CITY OF ALBUQUERQUE

**RE: 4331 Wyoming Blvd NE
Grading and Drainage Plan
Engineer's Stamp Date: 2/26/25
Hydrology File: G19D004
Case # HYDR-2025-00064**

Based upon the information provided in your submittal received 02/26/2025, the Grading & Drainage Plan is not approved for Building Permit and Grading Permit. The following comments need to be addressed for the approval of the above referenced project.

NOTE

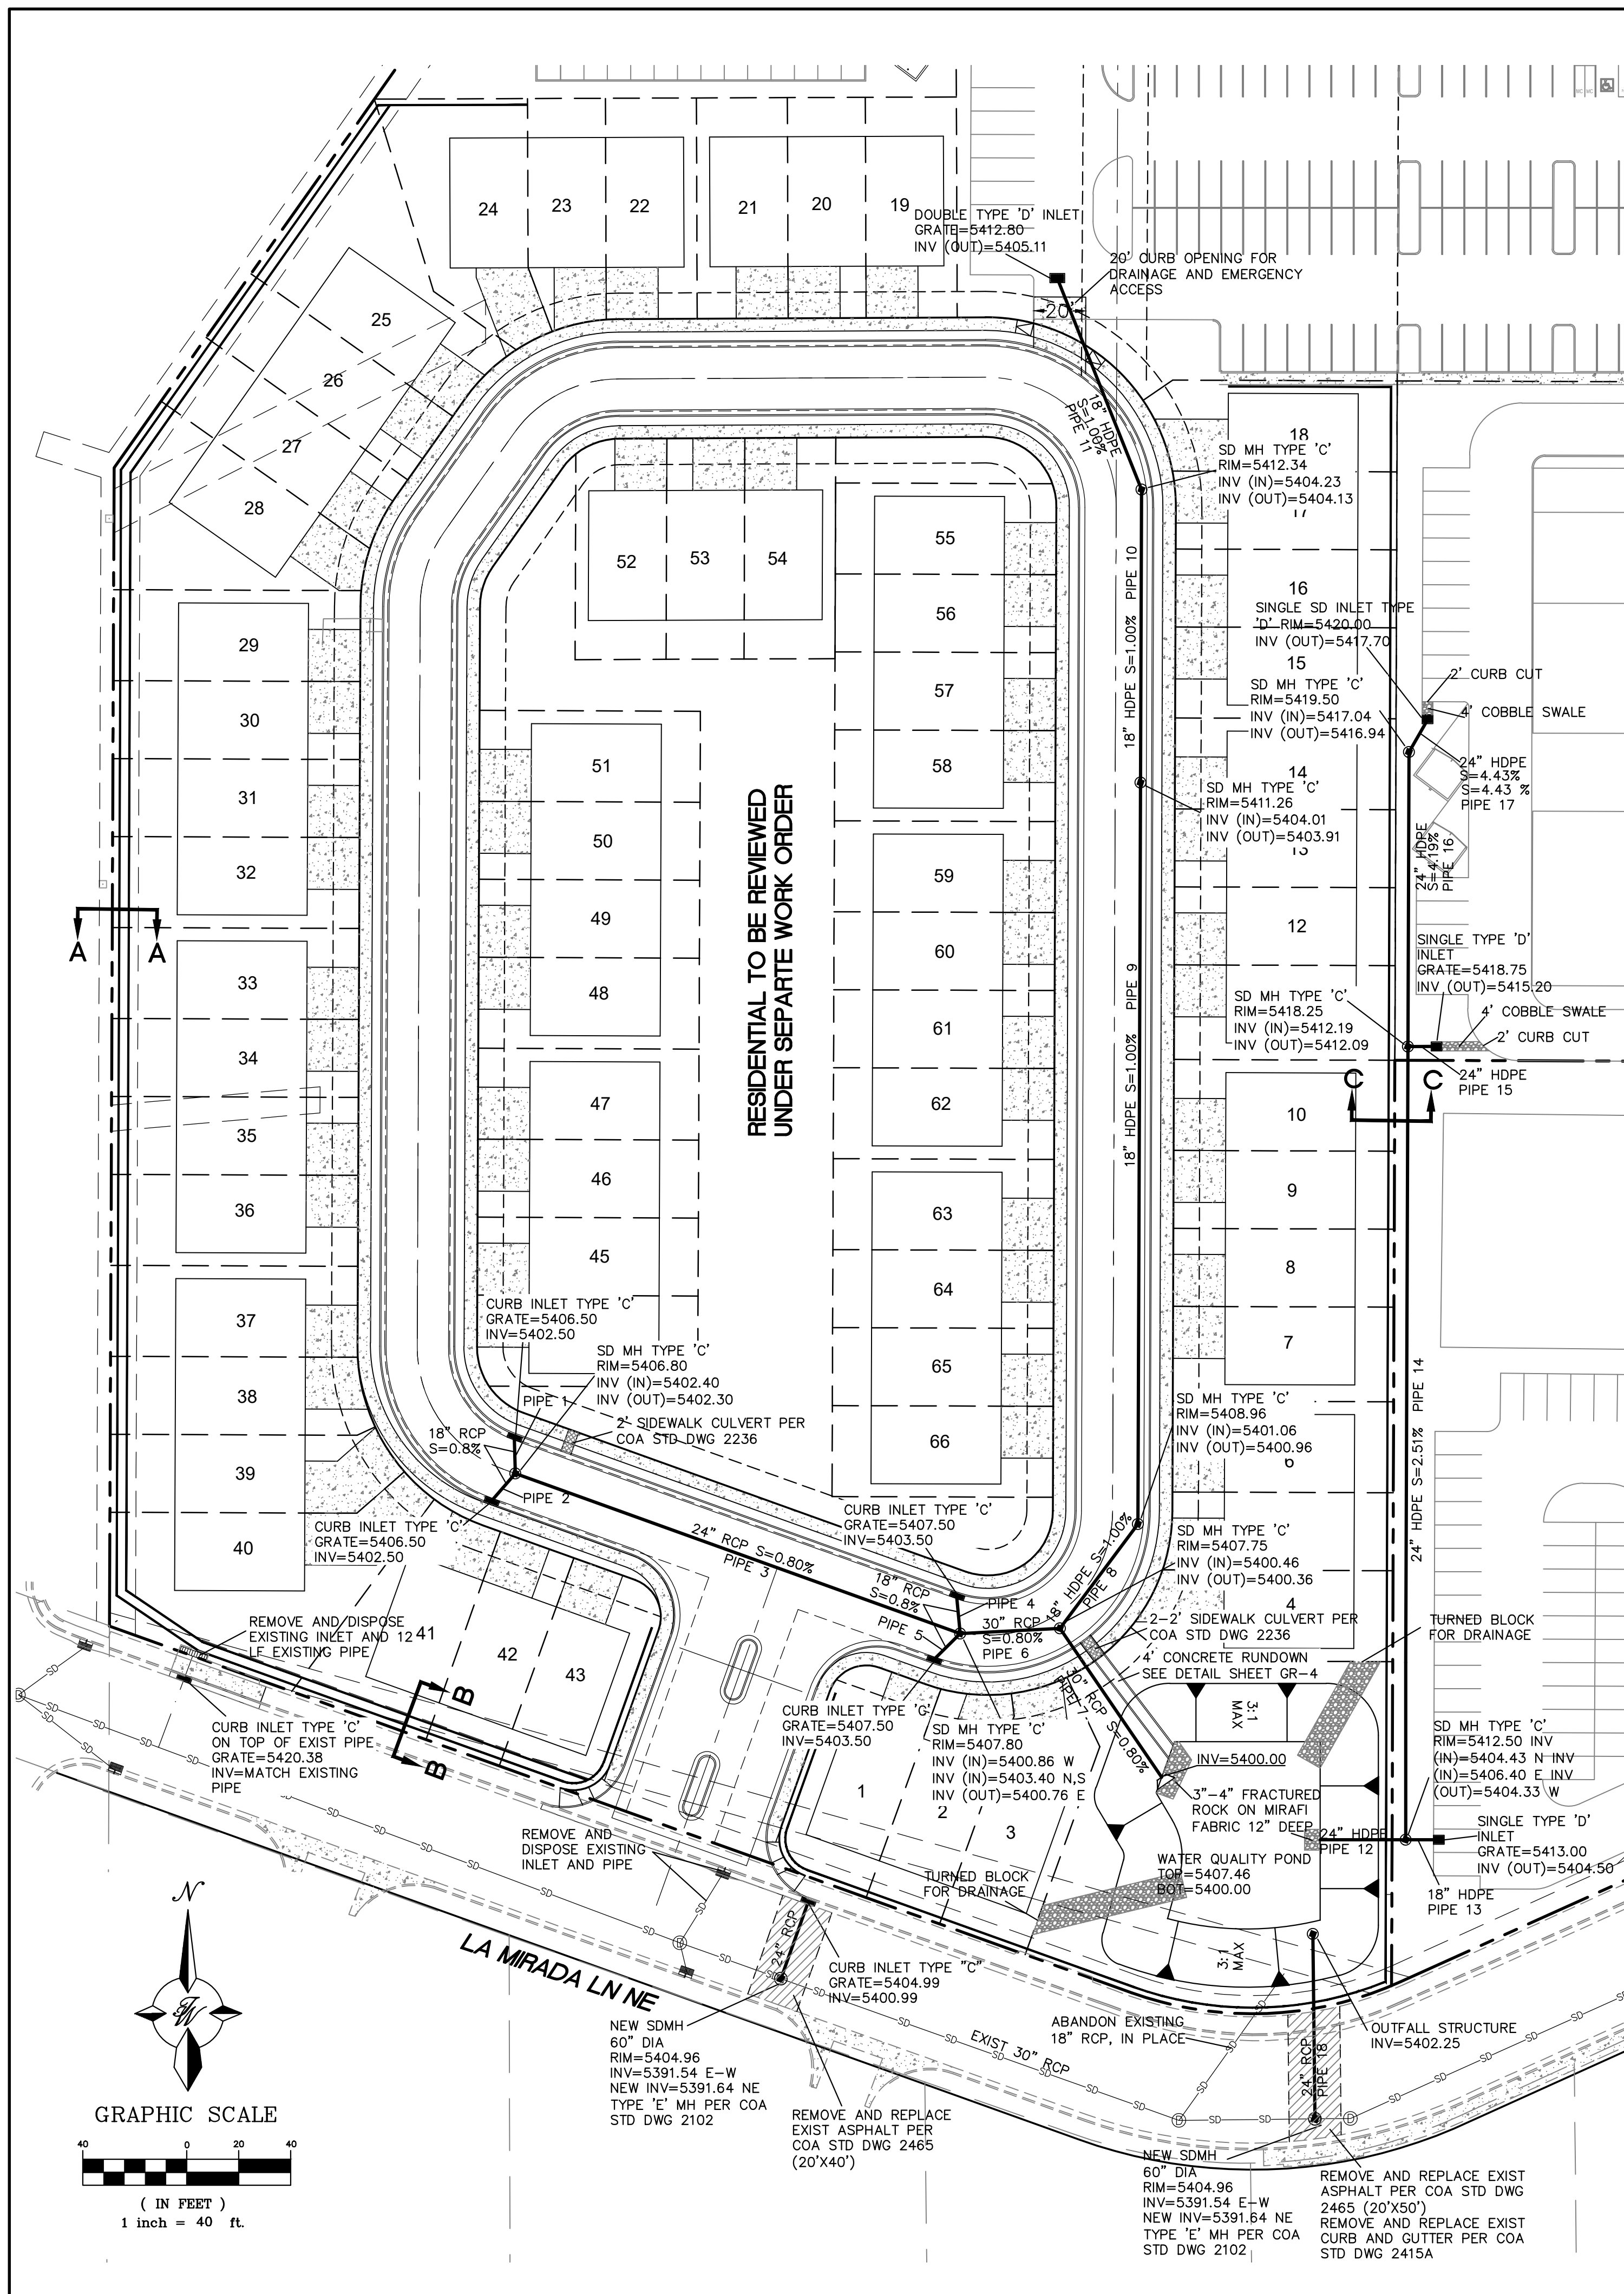
1. Please show the calculations for the SWQV. To calculate the required SWQV, multiply the impervious area draining to the BMP by 0.42 inches for new development sites and 0.26 inches for redevelopment sites. The calculations of both the required and the provided volume of each BMP must be shown on the Grading and Drainage Plan.
